**From:** Martina Mackin  
**Sent:** 22 February 2021 11:11  
**To:** Nick Wright  
**Subject:** RE: -21/00101/FUL

Drawing  
**Proposed Ground and  
 First Floors**

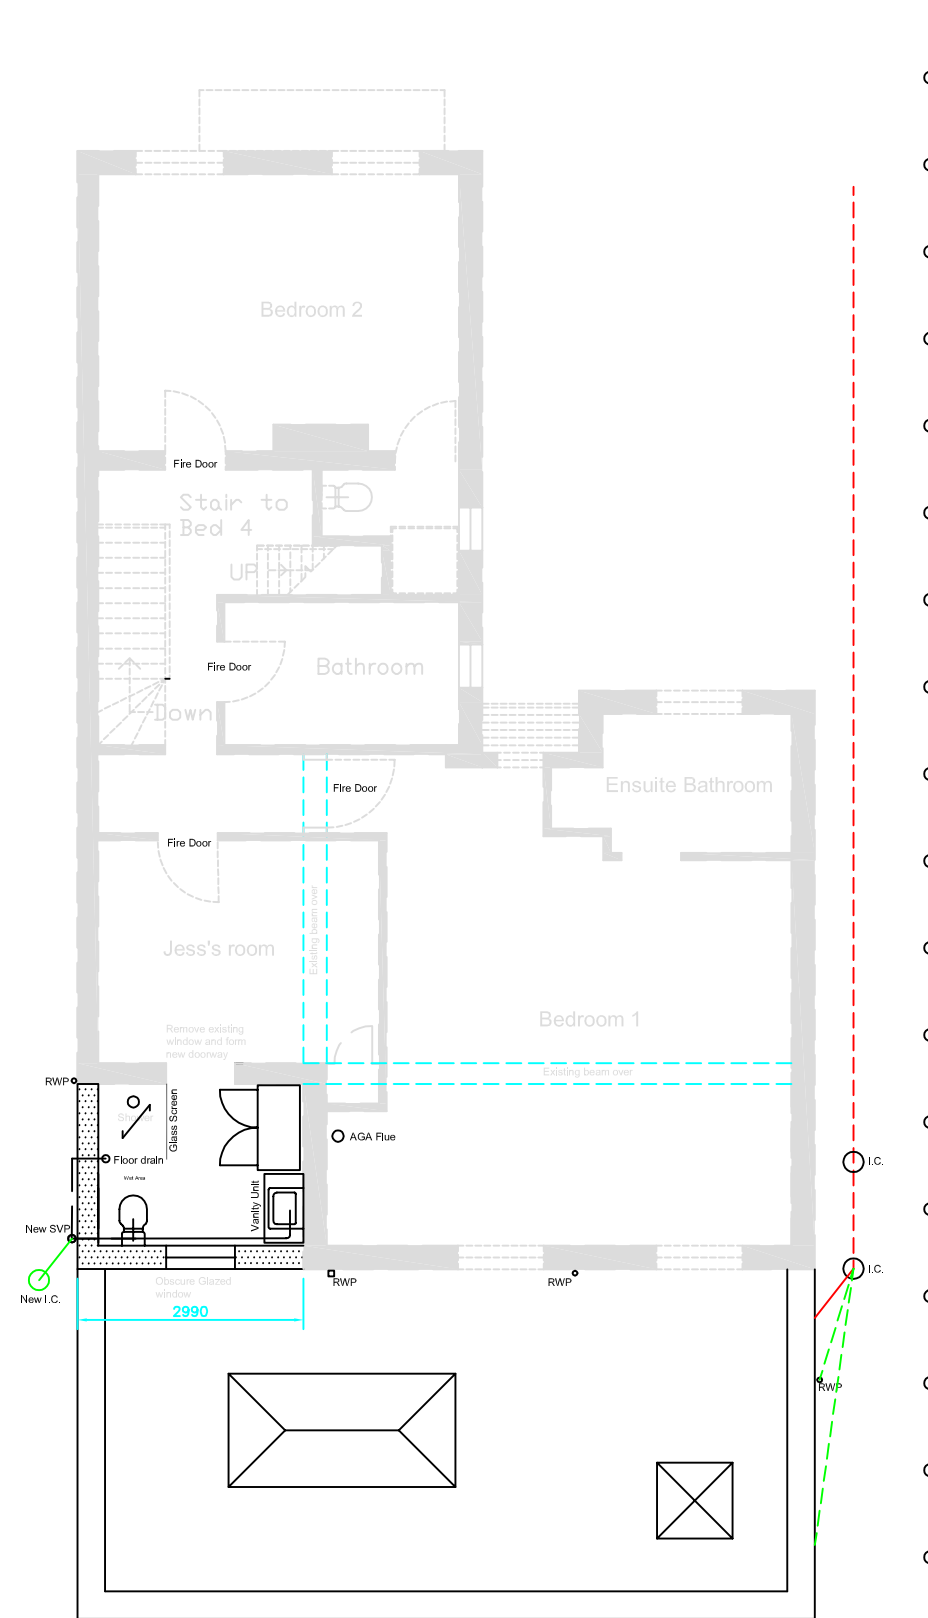
One more issue that still seems to be present is the window shown below, it does not appear to be shown on the existing or proposed floor plans but it is present on both elevational plans.
